REQUEST

Current Zoning: N1-A (neighborhood 1-A)
Proposed Zoning: CG(CD) (general commercial, conditional)

Approximately 3.85 acres located at the southwest intersection of Oakdale Road and Mt. Holly-Huntersville Road, north of Interstate 485.

The petition proposes a neighborhood shopping center with up to 31,500 square-feet of commercial/retail space as allowed in the General Commercial Zoning District.

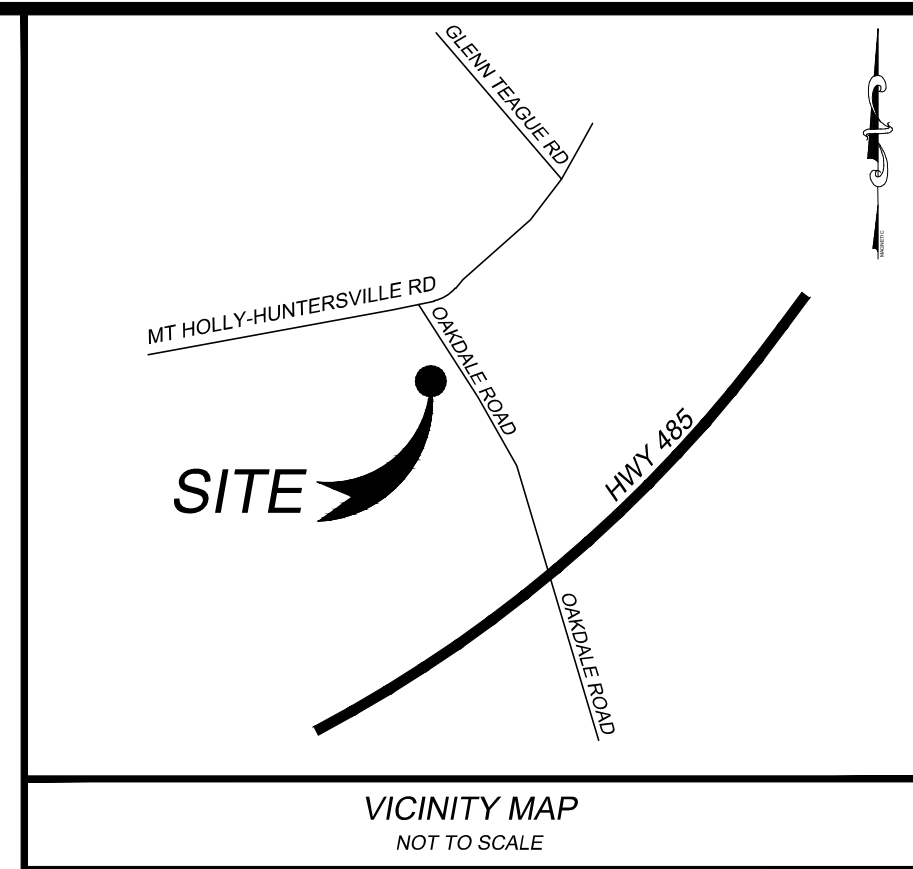
1. ~~Complete CTR summary table and include on the revised plan.~~ Addressed

2. ~~Tree save needs to be shown on the plans in a way that meets the ordinance. Tree save must be comprised of existing protected tree canopy.~~ Addressed
